**Re: San Felipe Plaza Parking Lot Grading & Drainage Plan**  
**Engineer's Stamp dated 8-27-02 (J13/D76)**

Based upon the information provided in your submittal dated 8-1-02, the above referenced plan is approved for Paving Permit. An SO#19 Permit is not necessary since you are not adding a sidewalk culvert or connecting to the back of an inlet. A driveway permit will be required but another department grants that permit. Upon completion of the project, please provide a certified as-built for our records.

SAN FELIPE PLAZA PARKING LOT GRADING & DRAINAGE PLAN

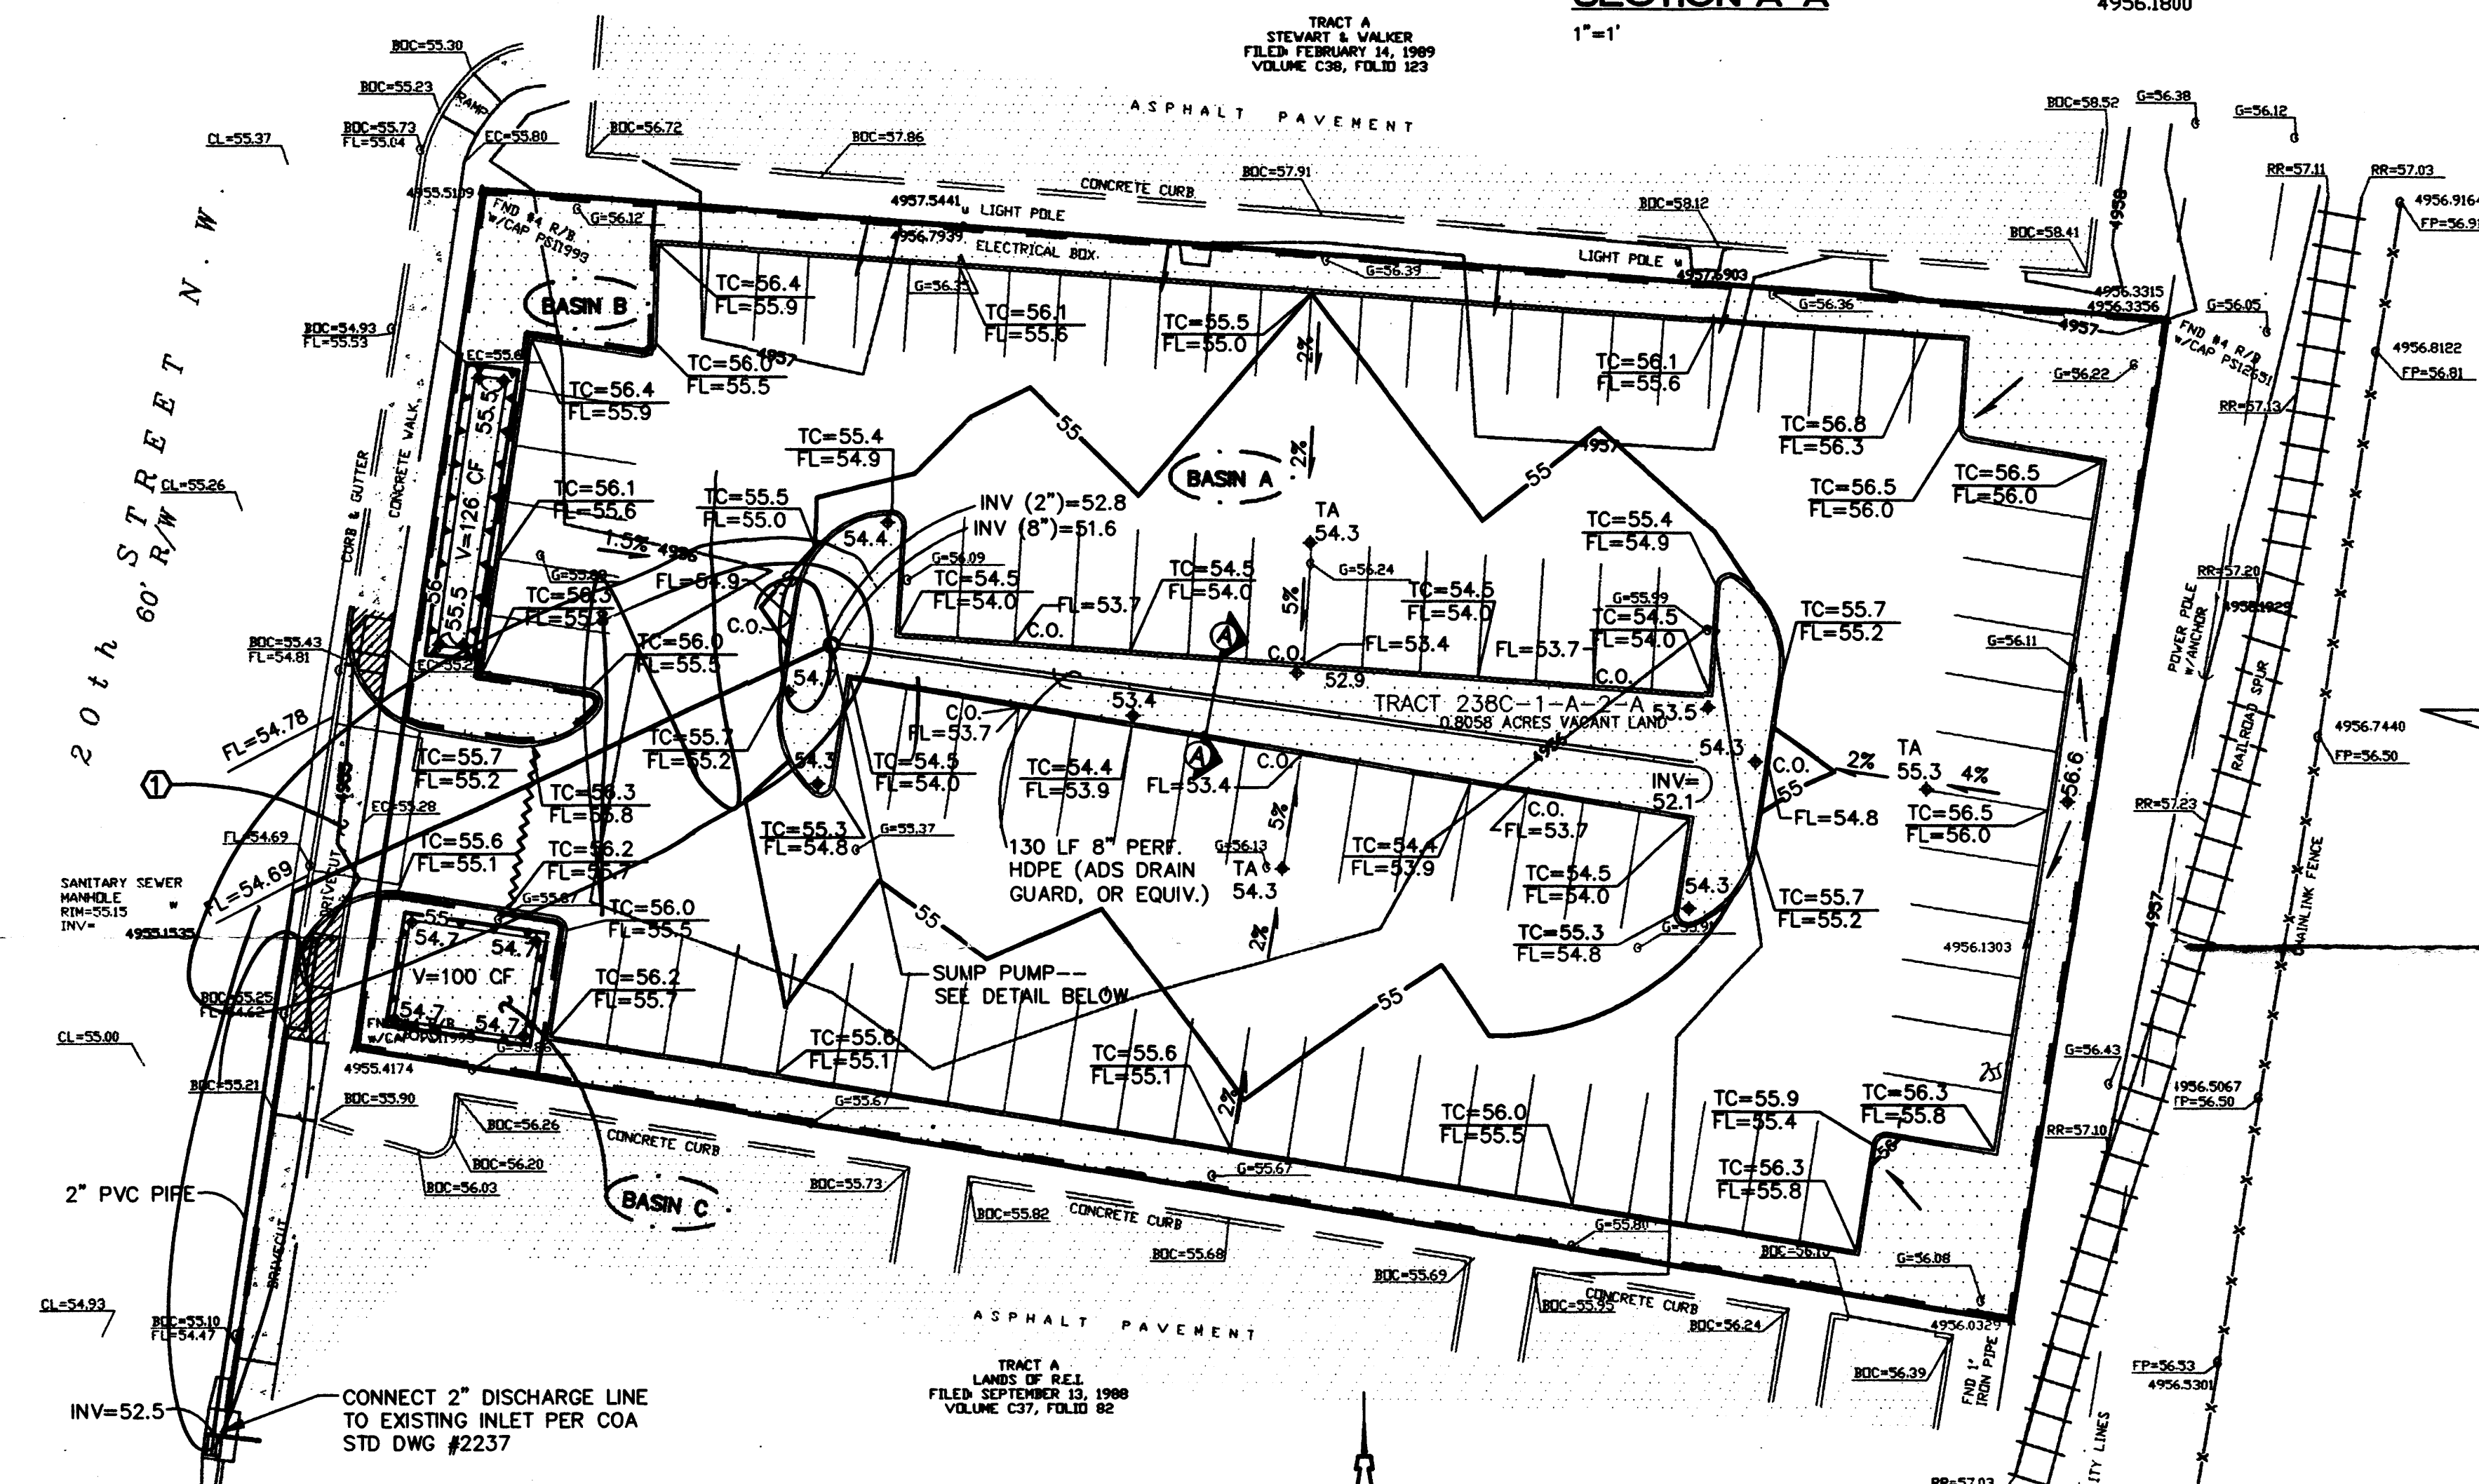
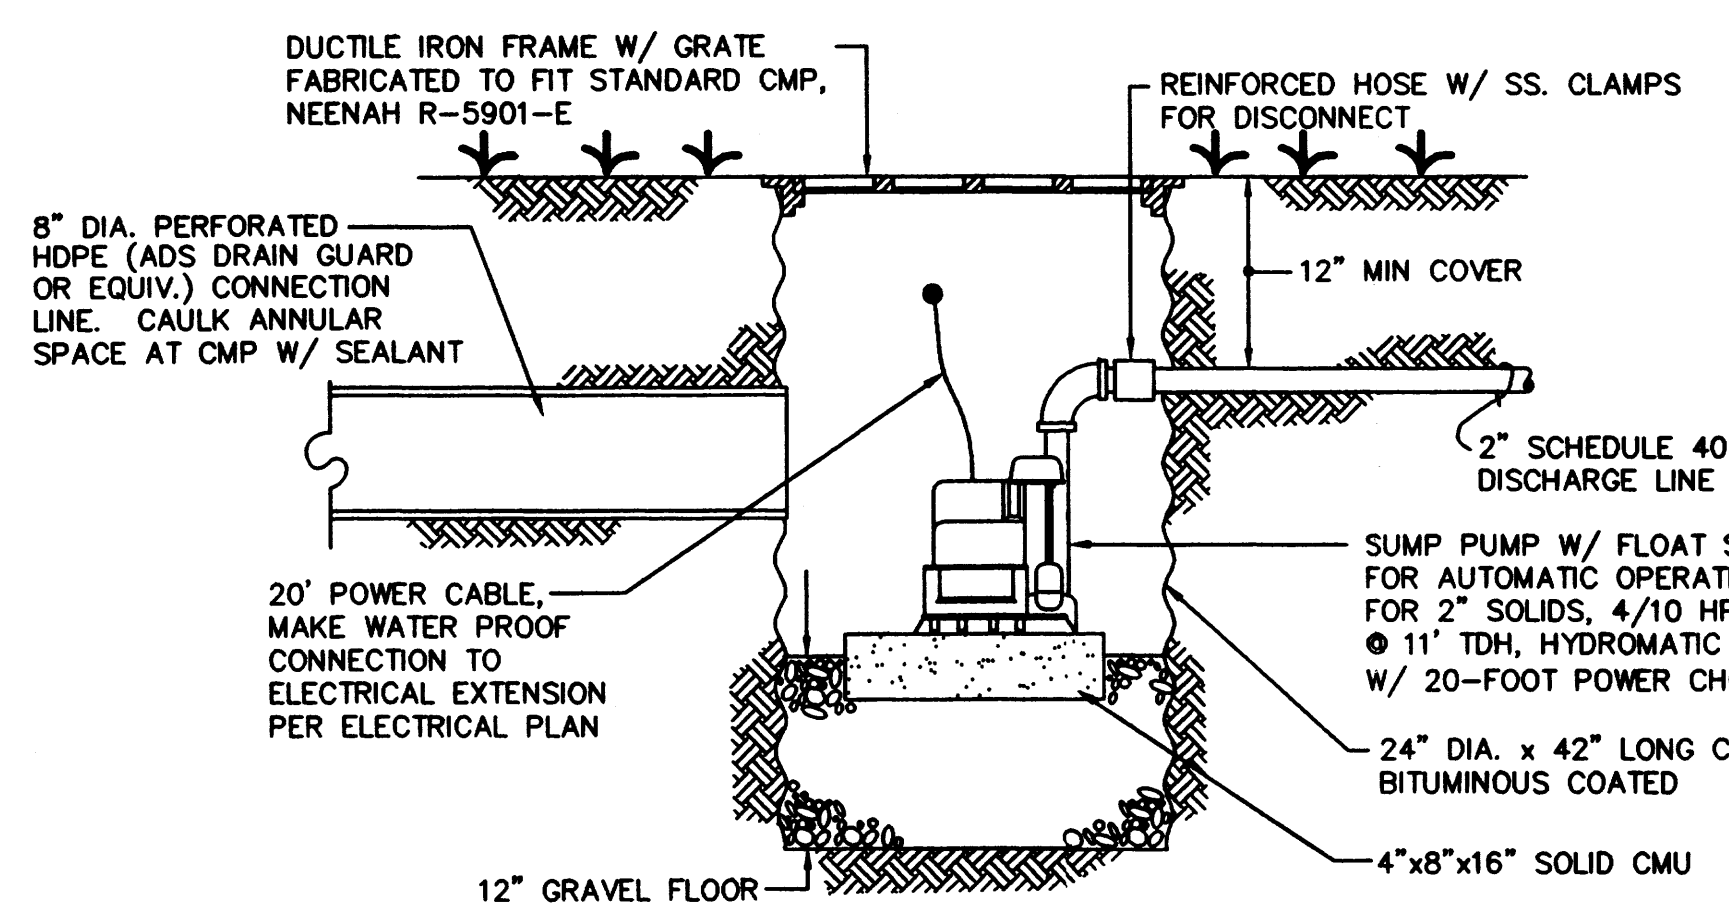
- The SO#19 Permit is a mechanism to connect to the back of an inlet or install a sidewalk culvert in order to forego the need for a Work Order. Since this project proposes to remove and replace a fair amount of curb and gutter, a Work Order would be required. It would be better to design this project to drain out the drivepad, or at least as much as you can, and have a small "water harvesting feature in the median. 0.5% slope is attainable with a small amount of fill (much cheaper in the long run, compared to a sump pump).

- The sump pump and storm drain line have been eliminated.
- Approximately one third of the flows will drain out the drivepad to 20th Street, and the remaining two thirds will be ponded in the median.
